From: Sarah Bodigian-Sharpe <[REDACTED]>
Sent: 27 January 2020 13:19
To: Amber Willard <Amber.Willard@arun.gov.uk>
Subject: AW/337/19/A installation of various signage, The Ship Inn, Aldwick Street.

OBJECTION TO : AW/337/19/A . One Stop Store Application for signage on the Ship Inn site

FROM: THE ALDWICK COMMUNITY SOCIETY

PROPOSED SITE SIGNAGE

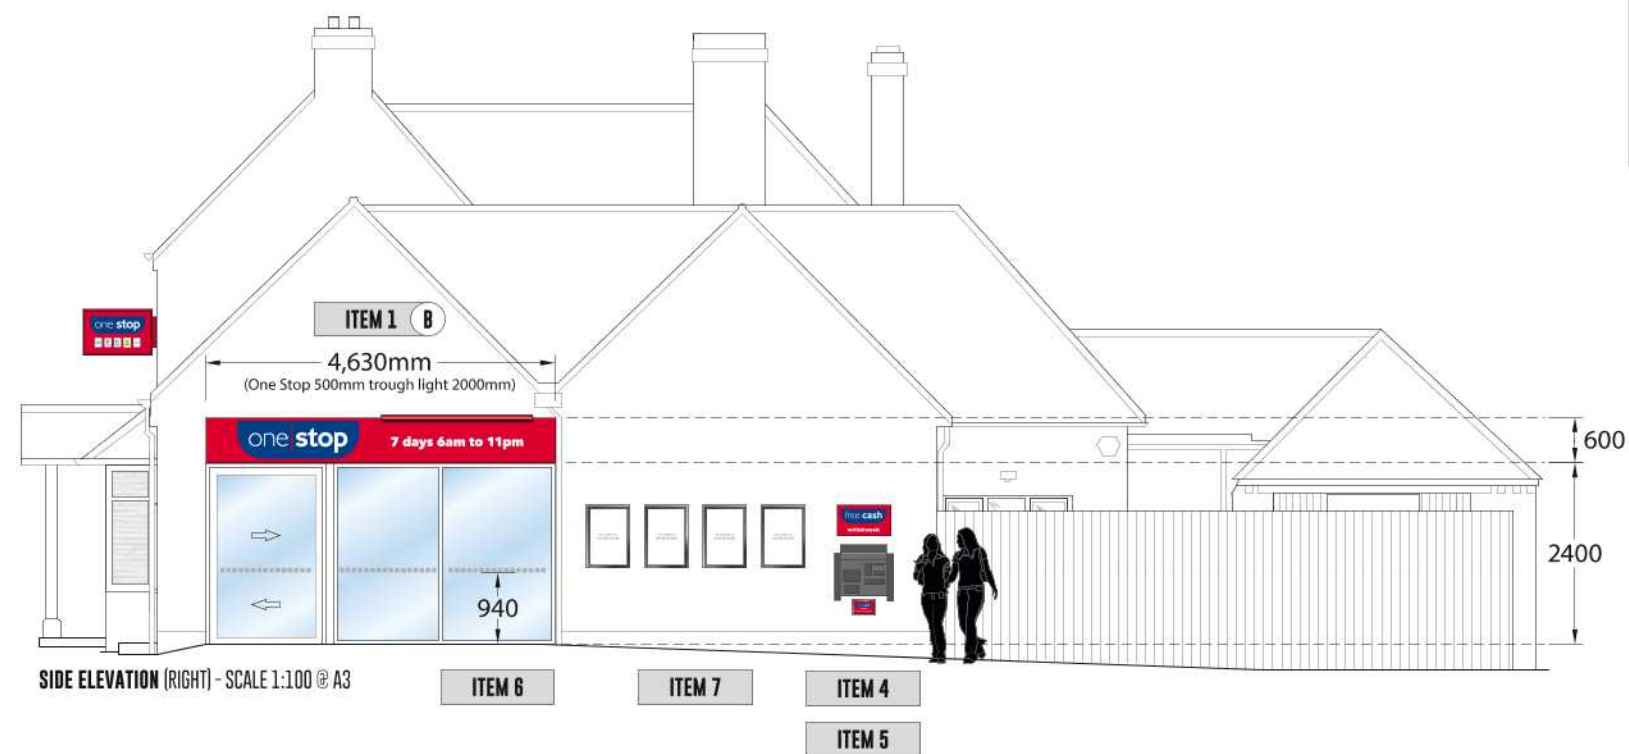
The proposed sign in the car park entrance is an invitation to motorists to pull in quickly into the car park. Aldwick Street is busy and narrow so any unexpected manoeuvre is likely to be a safety hazard for following vehicles, and others trying to exit the car park.

ITEM 3 - ACM PANELS
ALUMINIUM COMPOSITE PANELS WITH DIGITALLY
PRINTED IMAGE TO FACE OF THE PANEL.

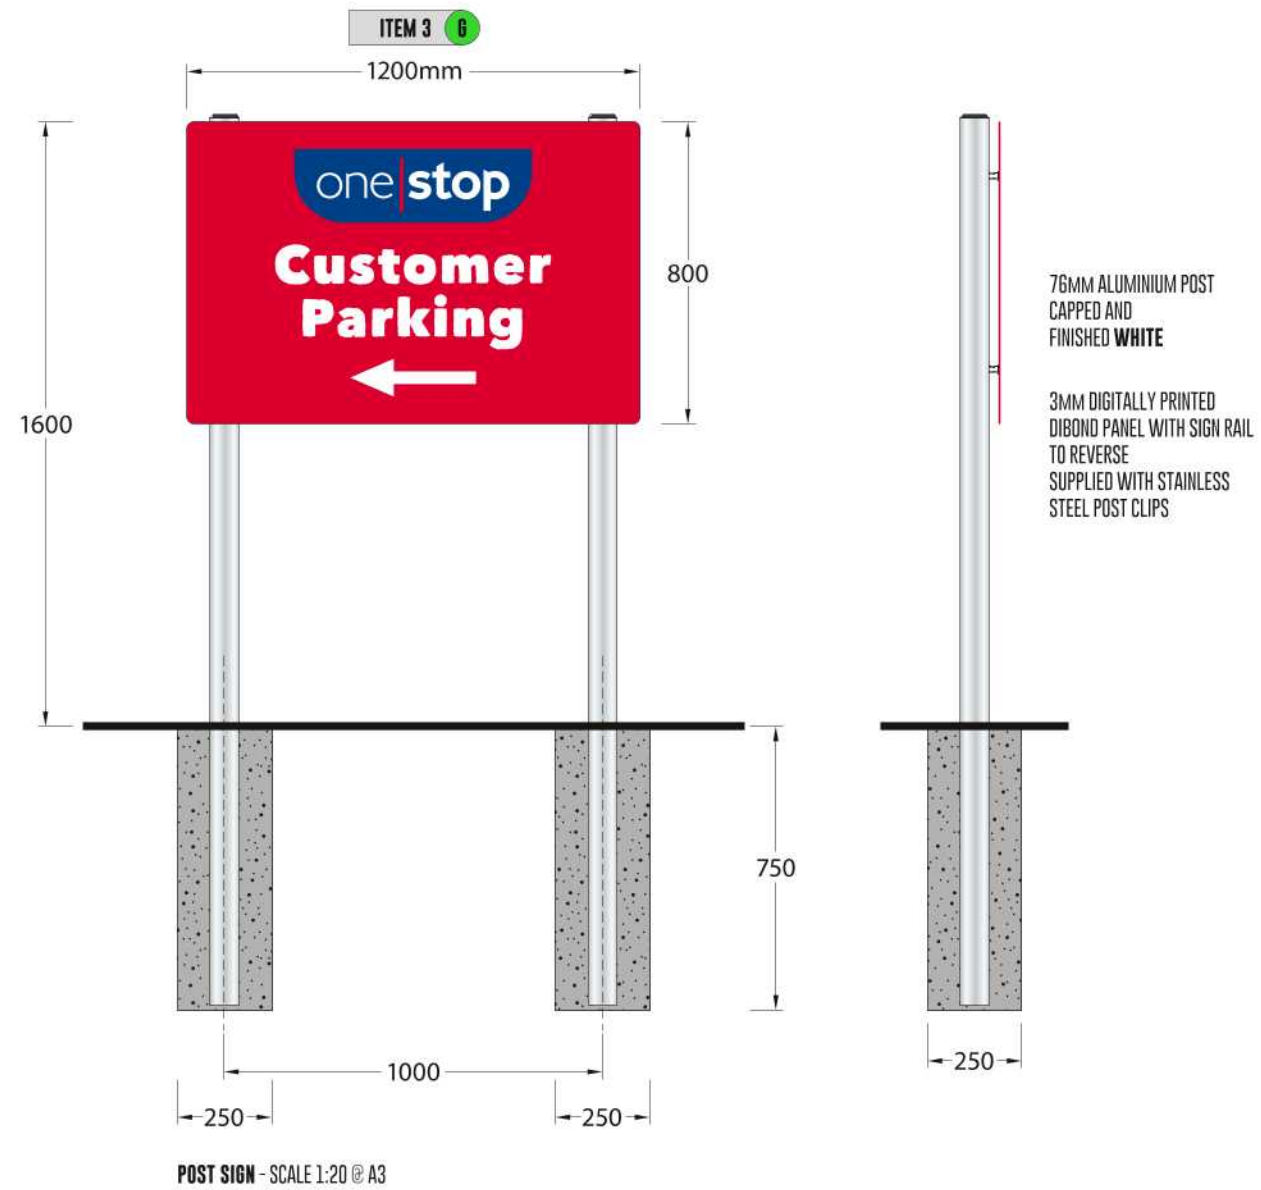
The proposed panels covering the bay windows disfigure the building and are out of character with the parade of shops on the other side of the road. There is also one extra panel proposed on the eastern end of the front elevation.
